# **Amendment Report**

## **Forest Glen Solar Farm**

**April 2022**

**Project Number: 22-029**

Figure 3-1 Updated indicative infrastructure layout for the Forest Glen Solar Farm. The Visual set-back area for R6 is located on the western boundary of the Proposal area. The Development footprint remains unchanged.

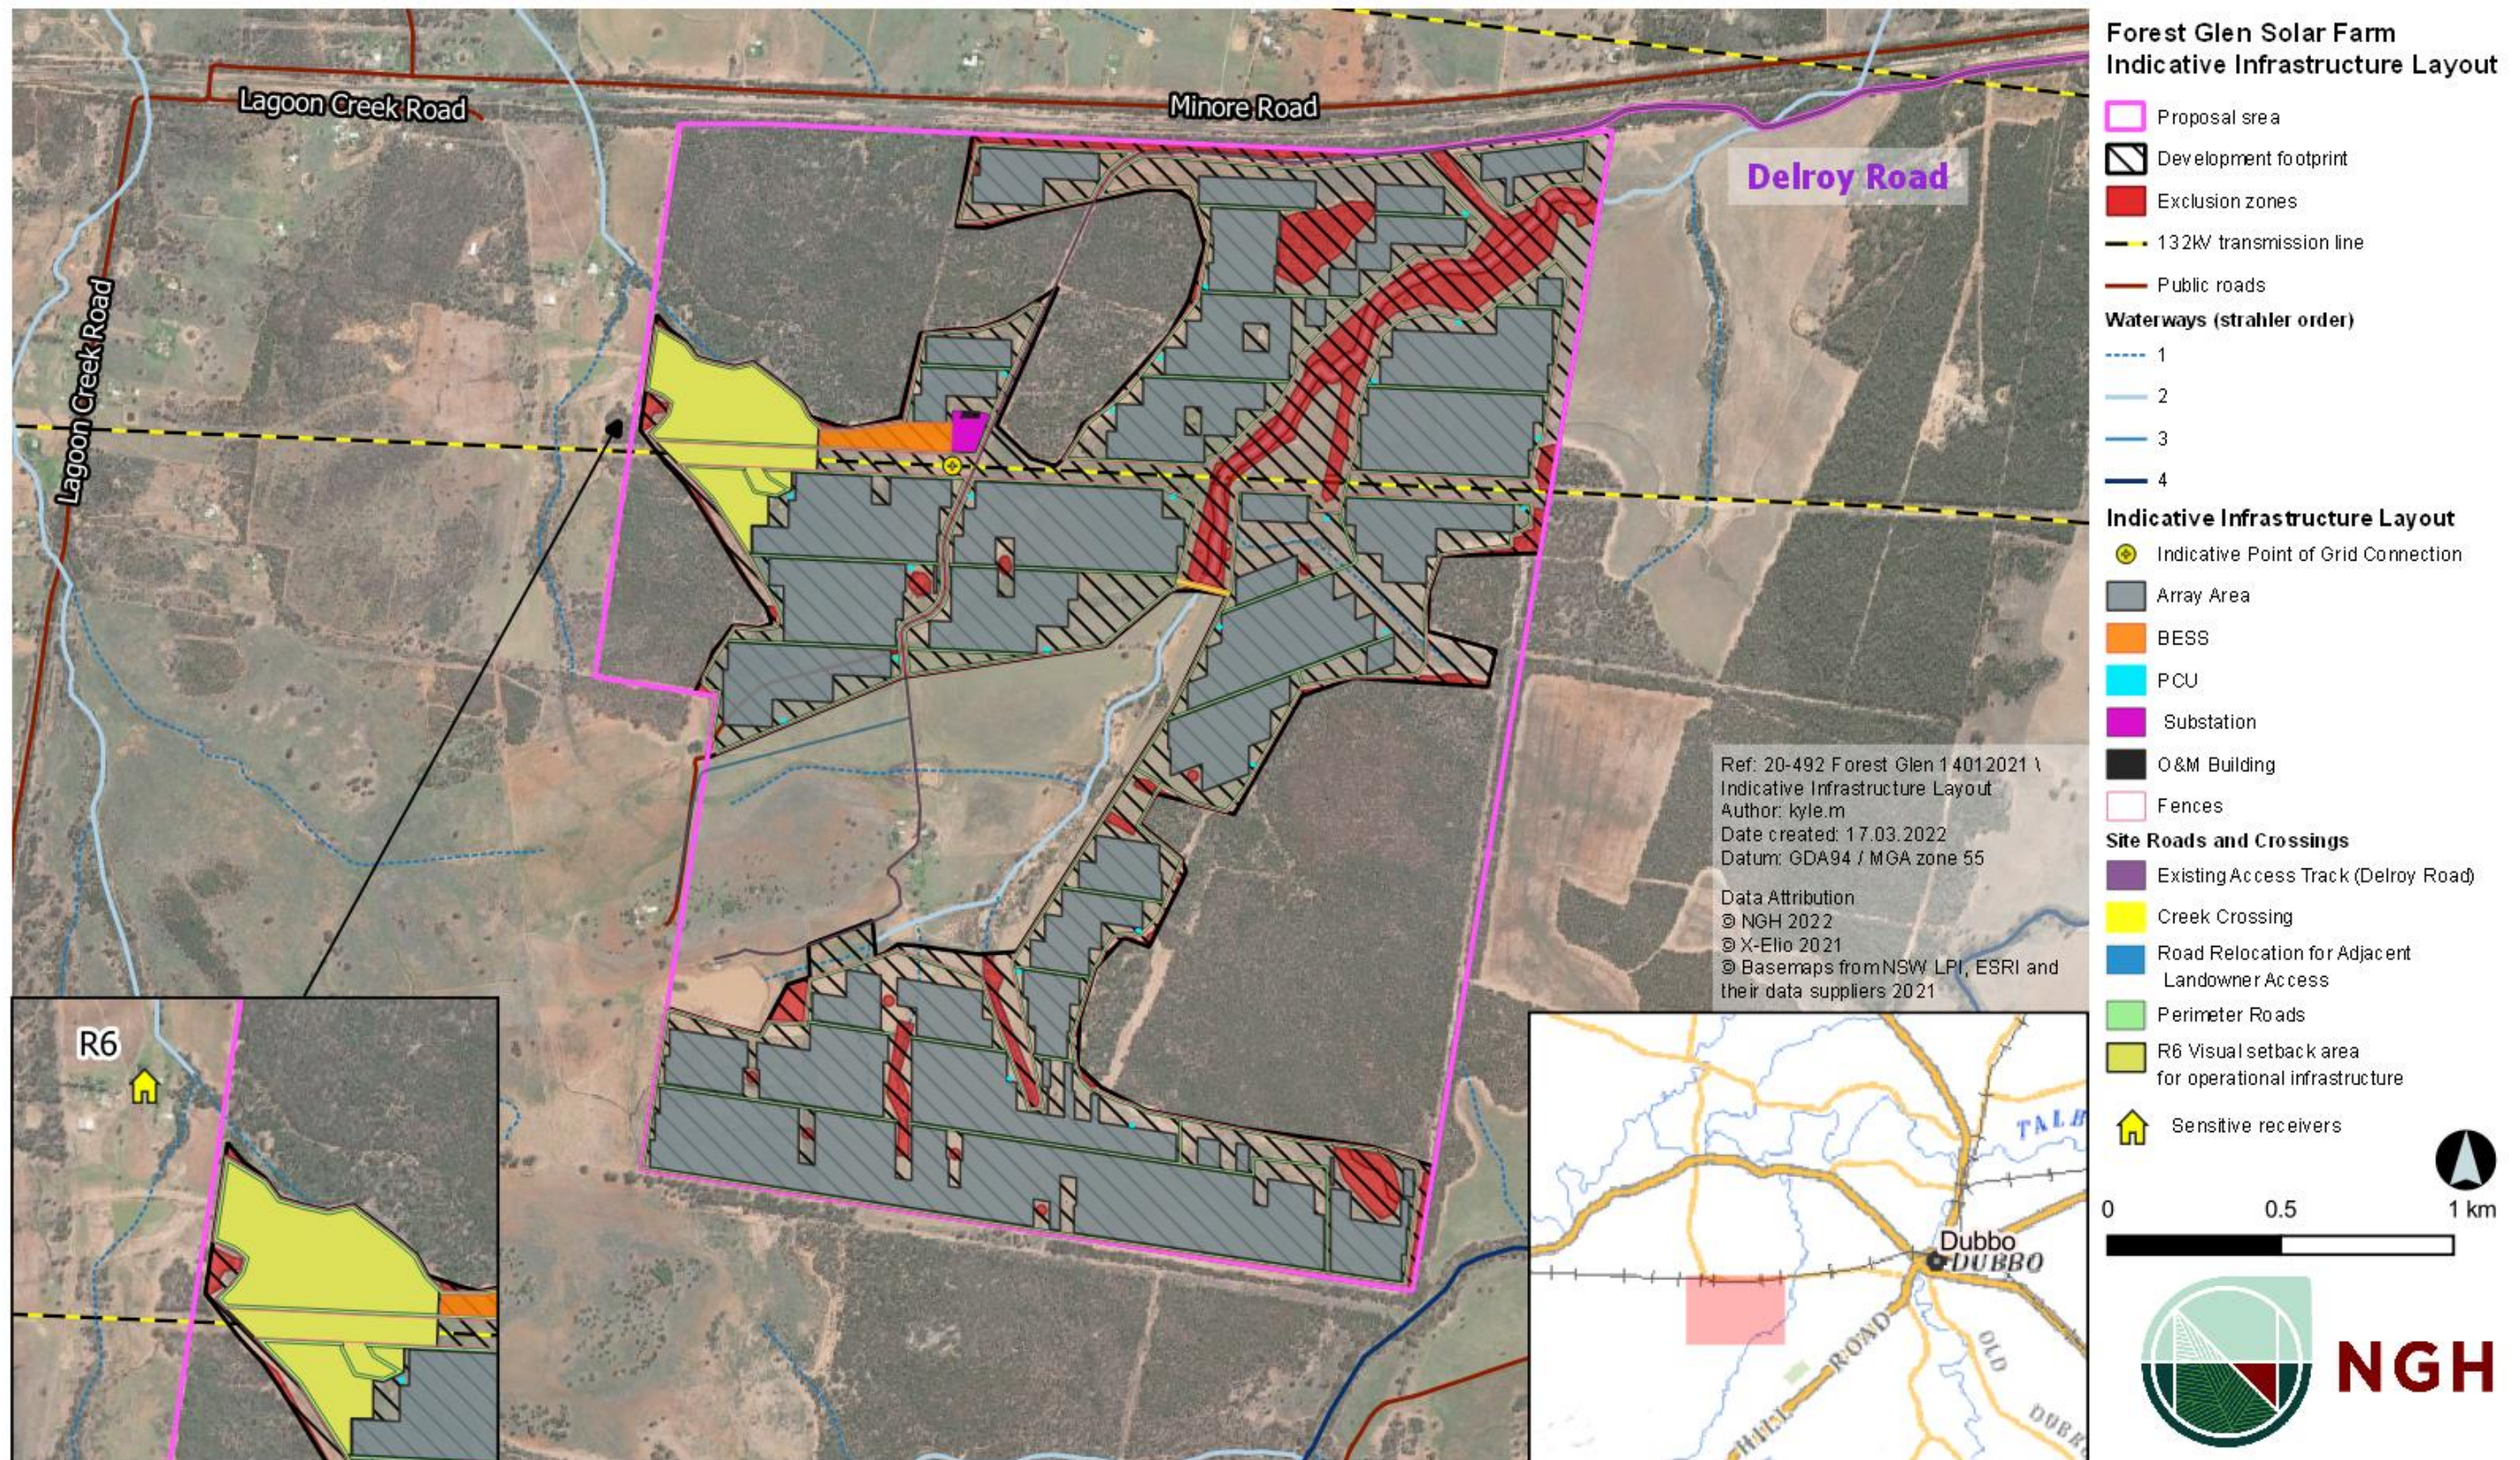
#### **3.2 Establishing a new visual set-back area for R6**

Following landowner consultation, the Proponent has committed to establishing a specific visual impact setback area on the western edge of the Proposal site to mitigate the visual impact of permanent above ground operational infrastructure to Receiver R6.

This visual setback area is now displayed as part of an updated indicative infrastructure layout for the Proposal in Figure 3-1 below and is reinforced in the updated visual impact mitigation commitments. The assessed Development footprint for which development consent is sought remains unchanged from the EIS, as construction works and the establishment of permanent tracks may still be required within this set back area.

- ***No above ground operational infrastructure would be constructed within the visual set-back area for R6 as mapped in Figure 3-1. This set back is included manage the operational visual, glare and glint impacts of the project on this receiver.***
- **No security lighting to be installed on this perimeter of the project, within 500m of the residence (R6).**

Figure 3-2 Lots 51/ DP755094 and Lot 52/DP755094. Right of carriageway now included for Lot 51.

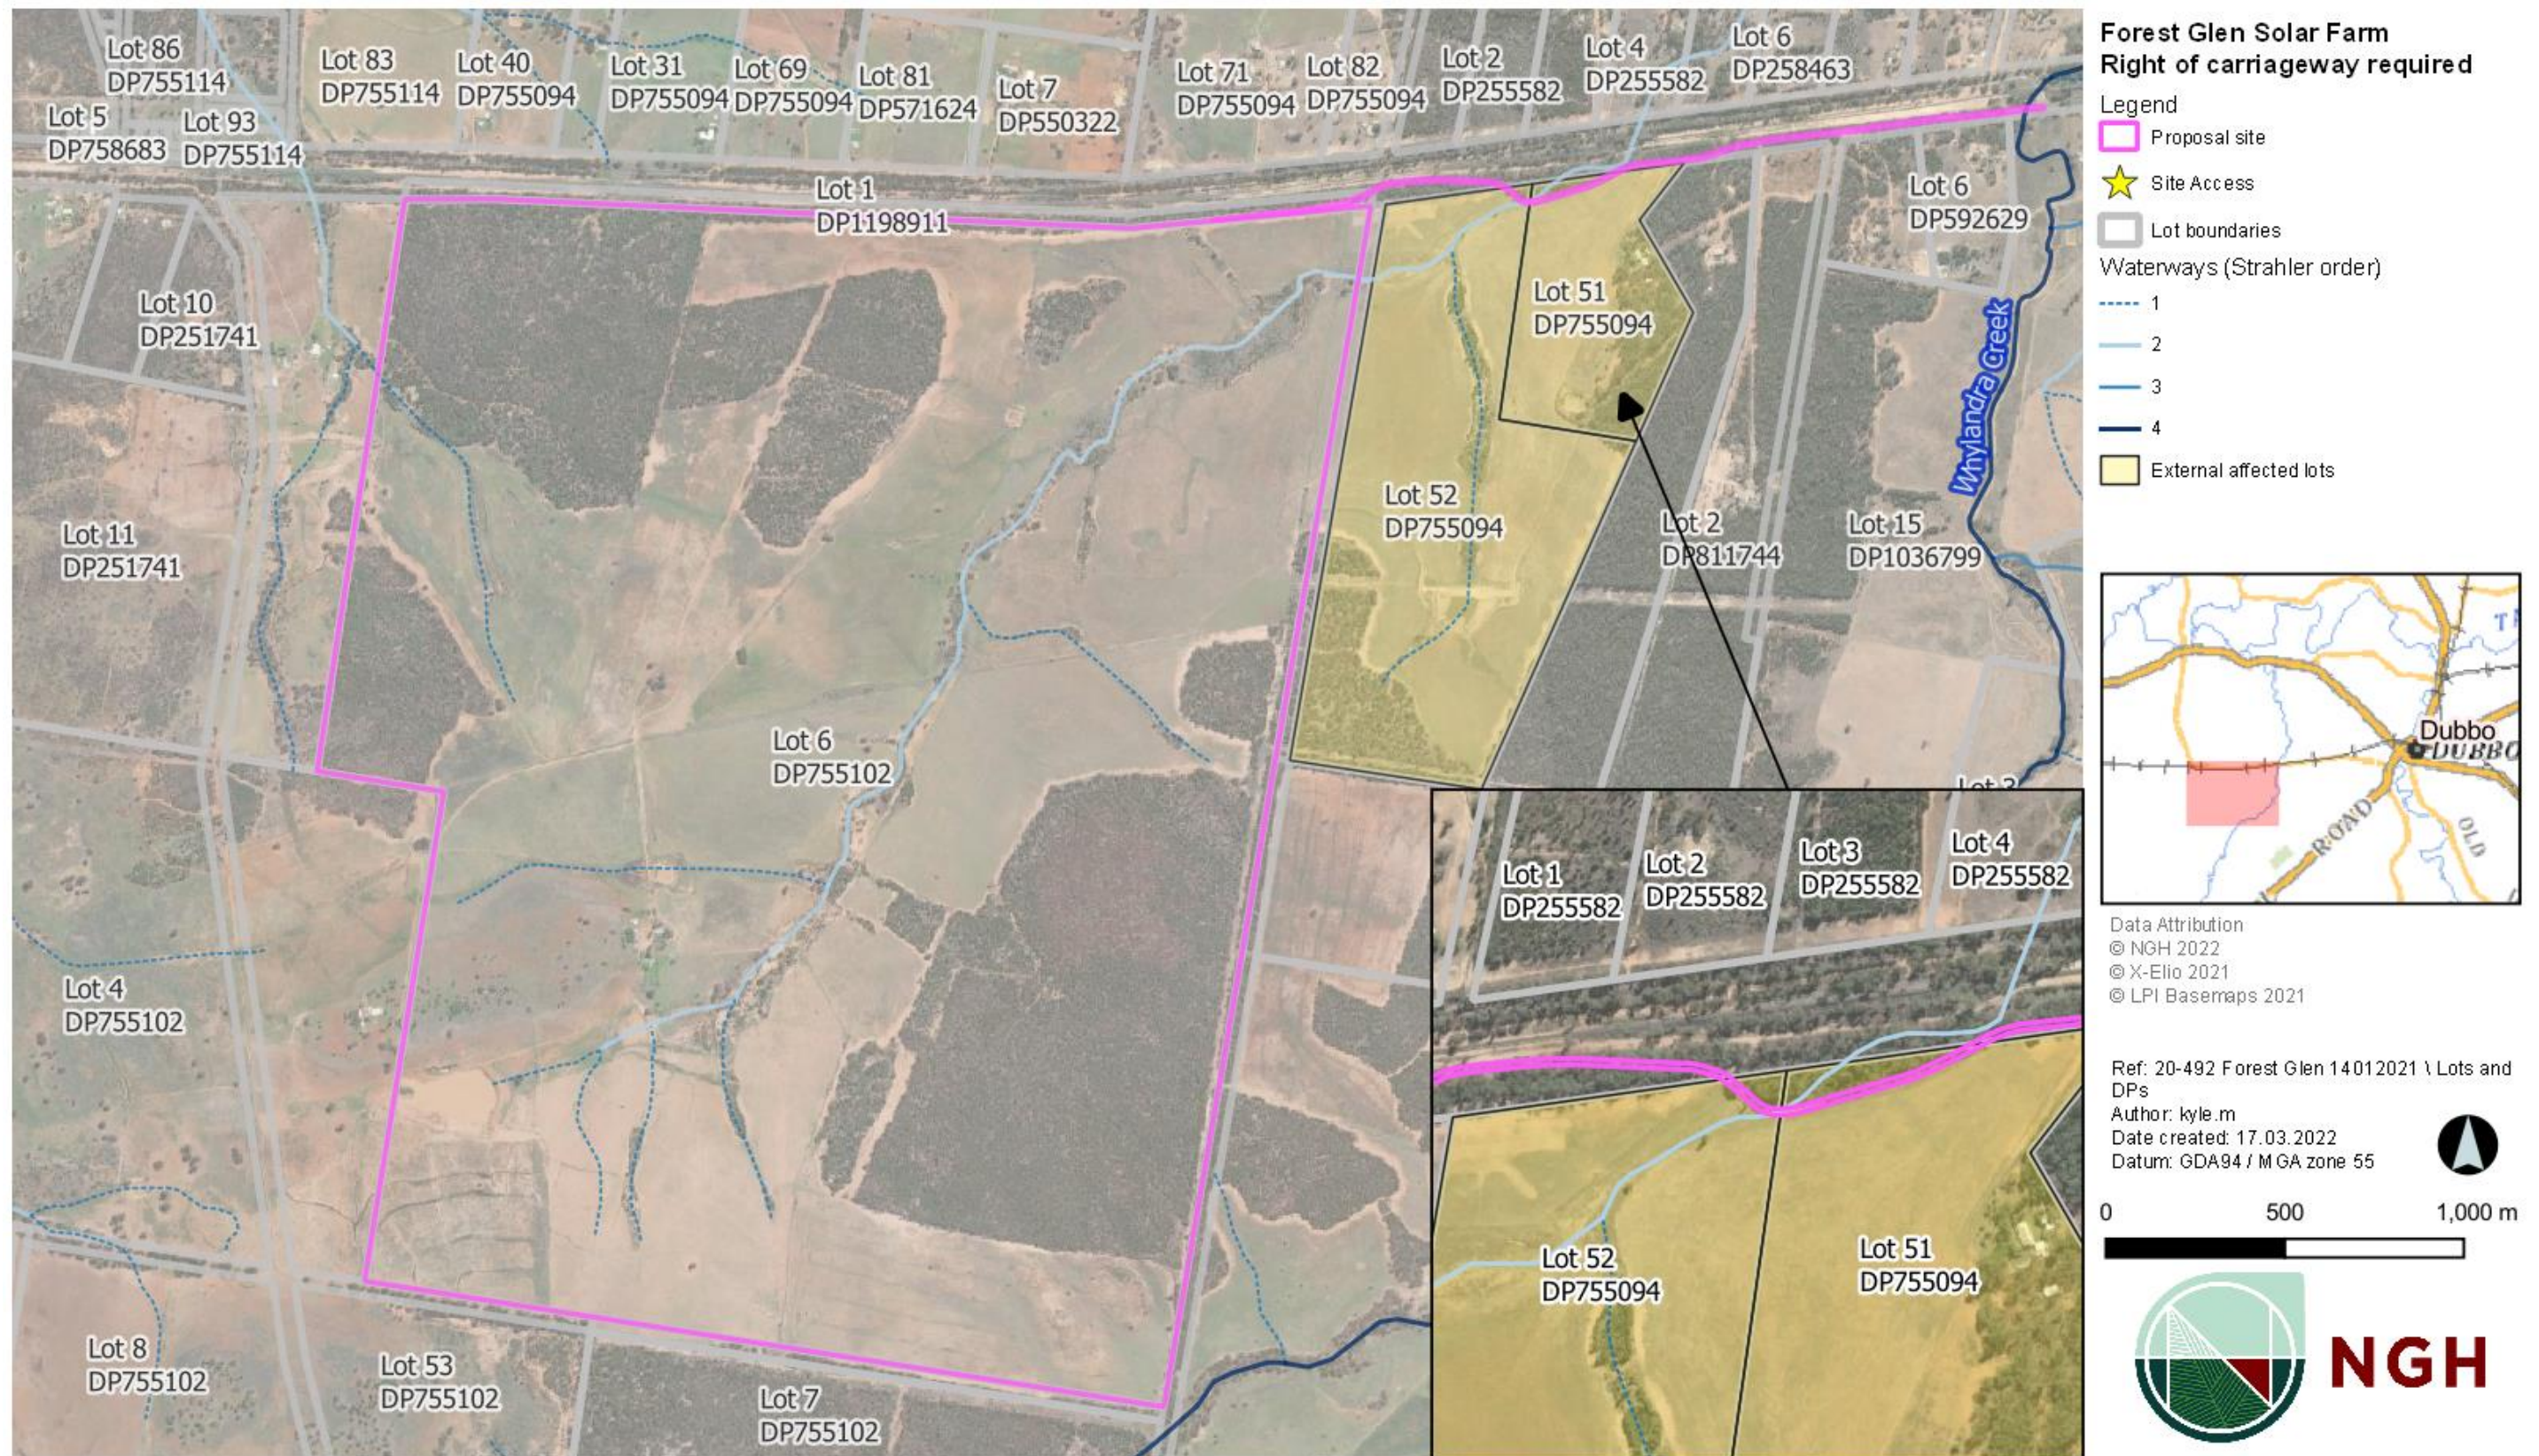
#### **3.3 Right of way carriageway**

As described in the EIS, Delroy Road would be the primary construction and operational site access road to the Proposal. Delroy Road has recently been gazetted as a local Council road. However, portions of it traverse private freehold (Lots 51/ DP755094 and Lot 52/DP755094). Refer Figure 3-2.

Following Council consultation, the Proponent has sought and obtained landowner consent to establish a right of way carriageway across these lots, to ensure legal access to the Proposal site. An additional land owner consent for right of access through the affected private lots has been provided to DPE with this Amendment Report.

Delroy Road has recently been gazetted as a local Council road. However, portions of it traverse private freehold (Lots 51/ DP755094 and Lot 52/DP755094). Refer Figure 3-2. Dubbo Regional Council have stated that it will be necessary for 'Rights of Carriageway' to be created to provide the landowner with legal access to the Proposal site. Following Council consultation, the Proponent has sought and obtained landowner consent to establish a right of carriageway , to ensure legal access to the Proposal site across these sections.
